**Consultation Response from KC,
Highways Development Management**

2024/93599 Barn Cottage, Corn Mill Bottom, Long Lane, Shelley, Huddersfield, HD8 8JJ

Demolition of existing dwelling and erection of detached dwelling and associated works

Date Responded: 16/07/2025.

1 PROPOSED SITE PLAN

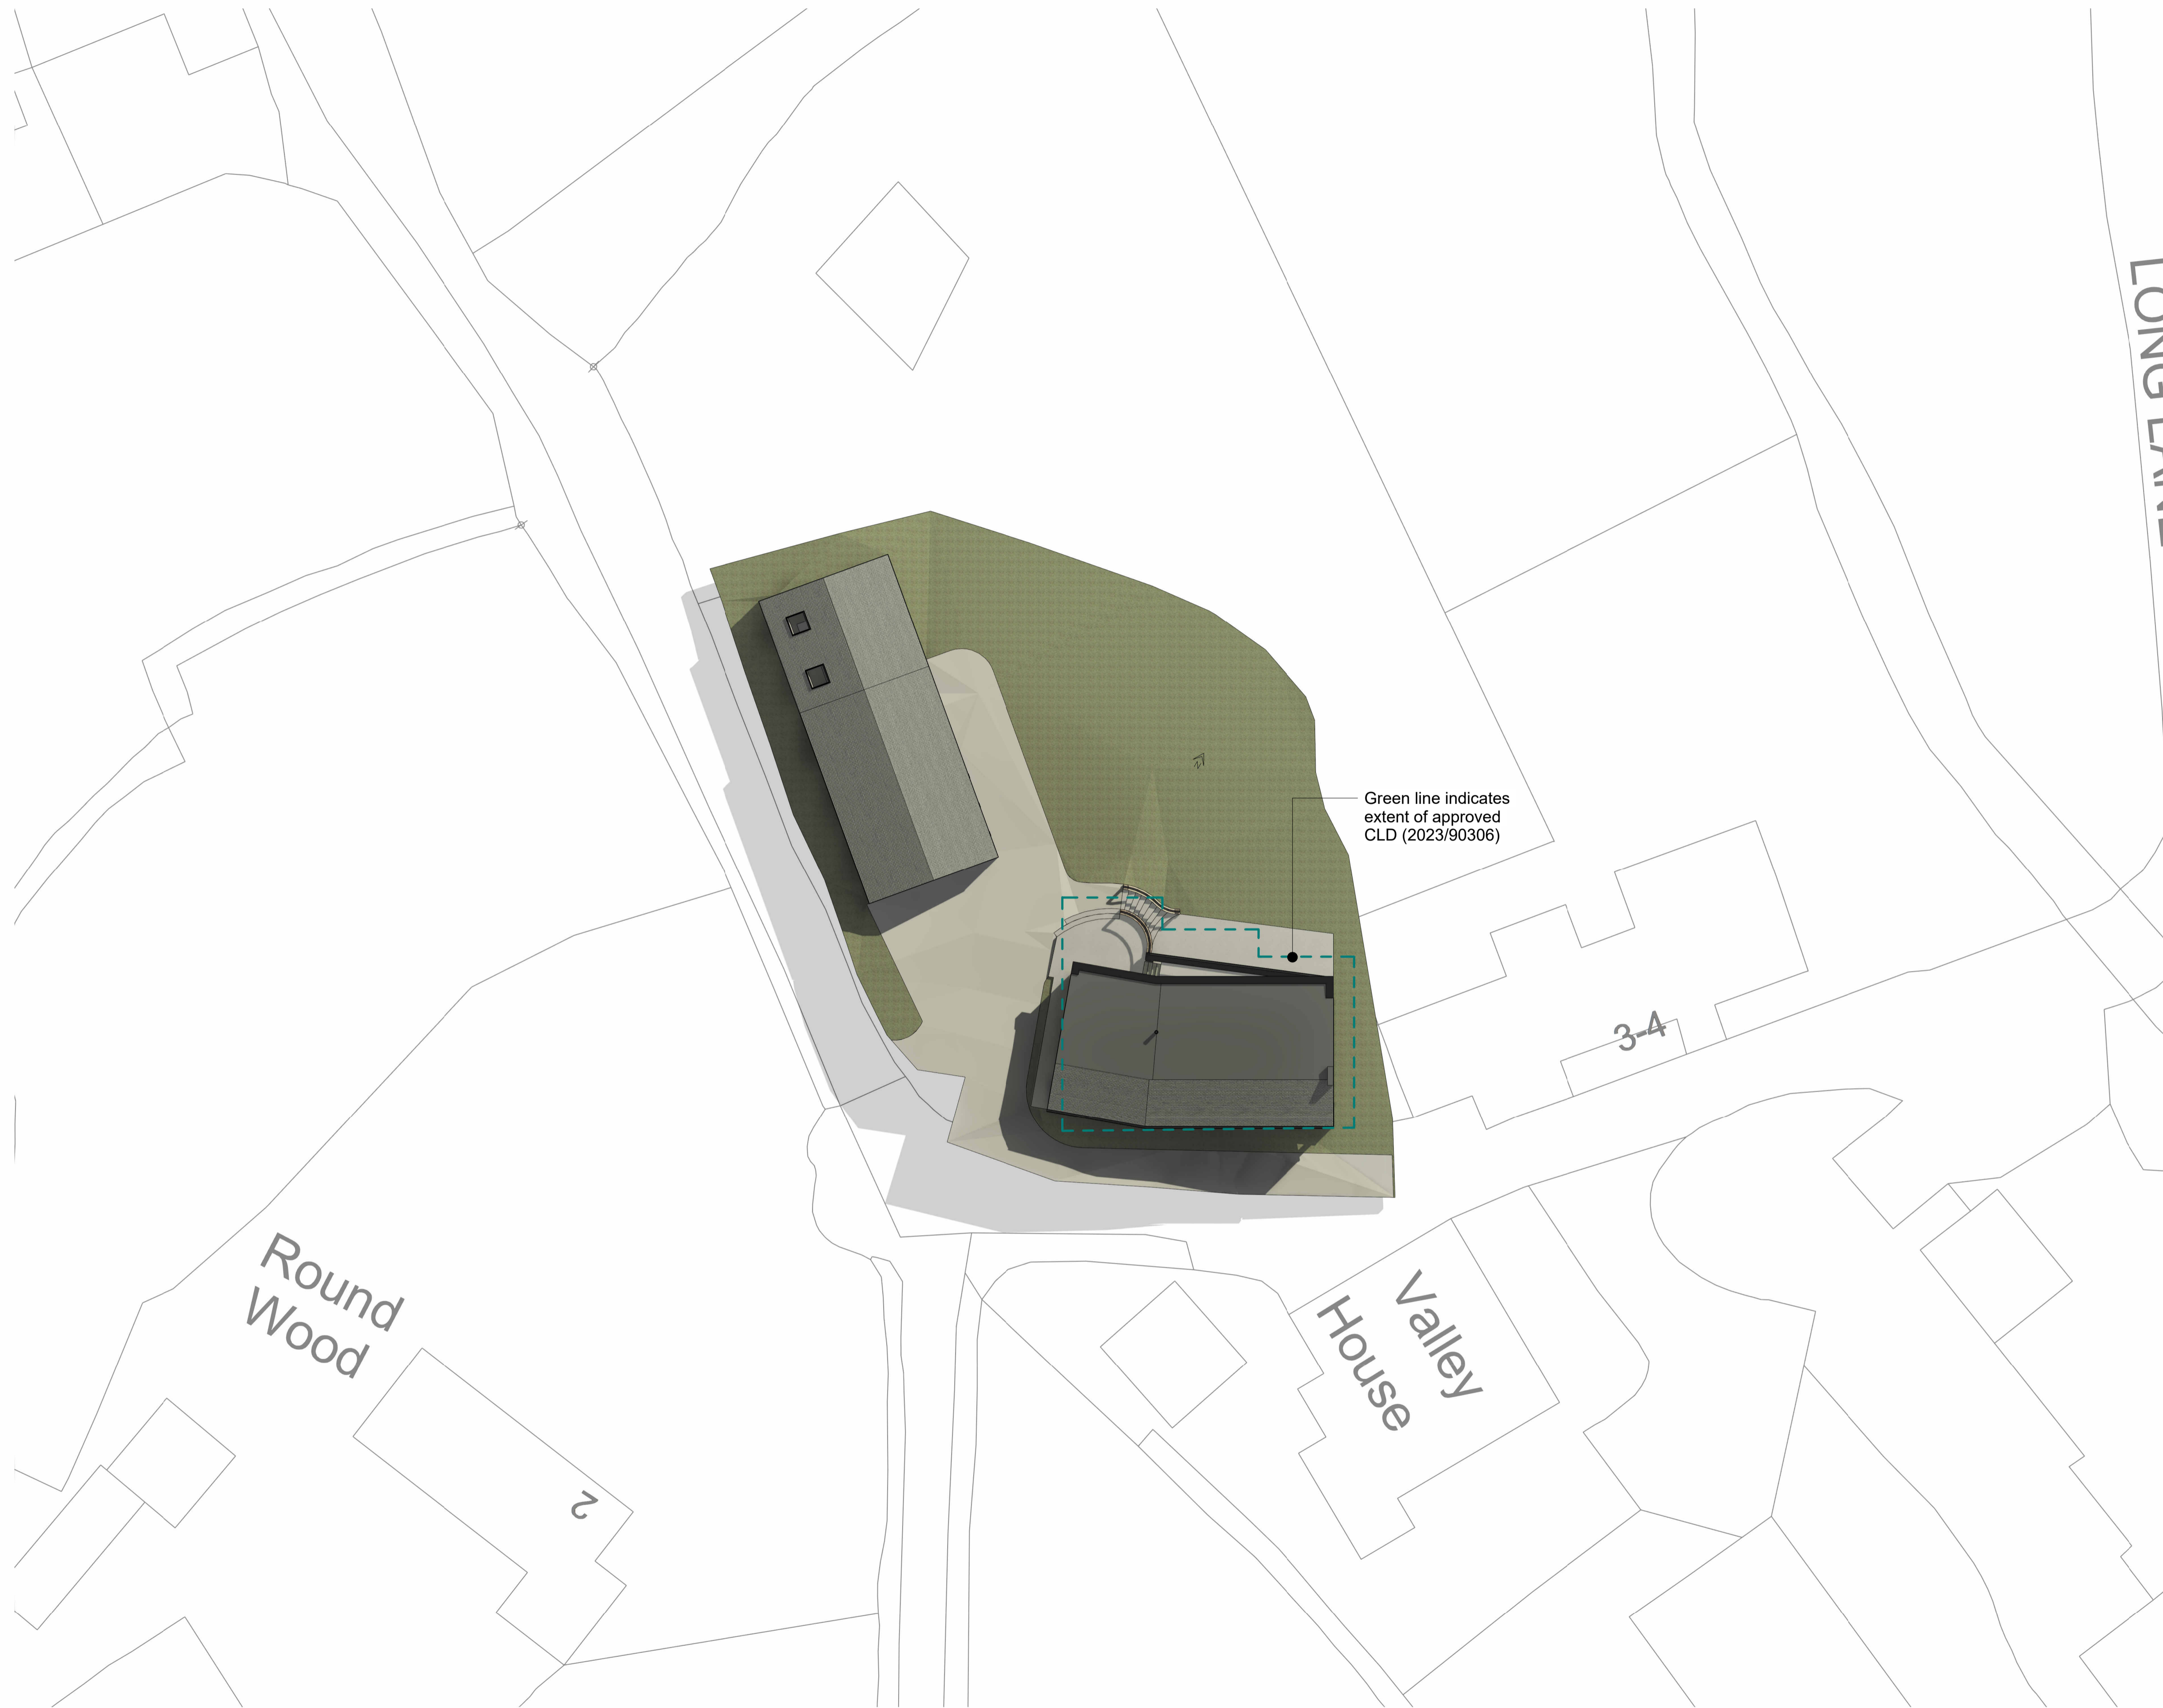
Vehicle access to the site onto Long Lane will remain as existing and is unaffected by the proposals.

Parking will remain as existing which is acceptable

The approved vehicle parking areas will need to be surfaced and drained in accordance with the Communities and Local Government; and Environment Agencies 'Guidance on the permeable surfacing of front gardens (parking areas)' published 13th May 2009 (ISBN 9781409804864) as amended or superseded.
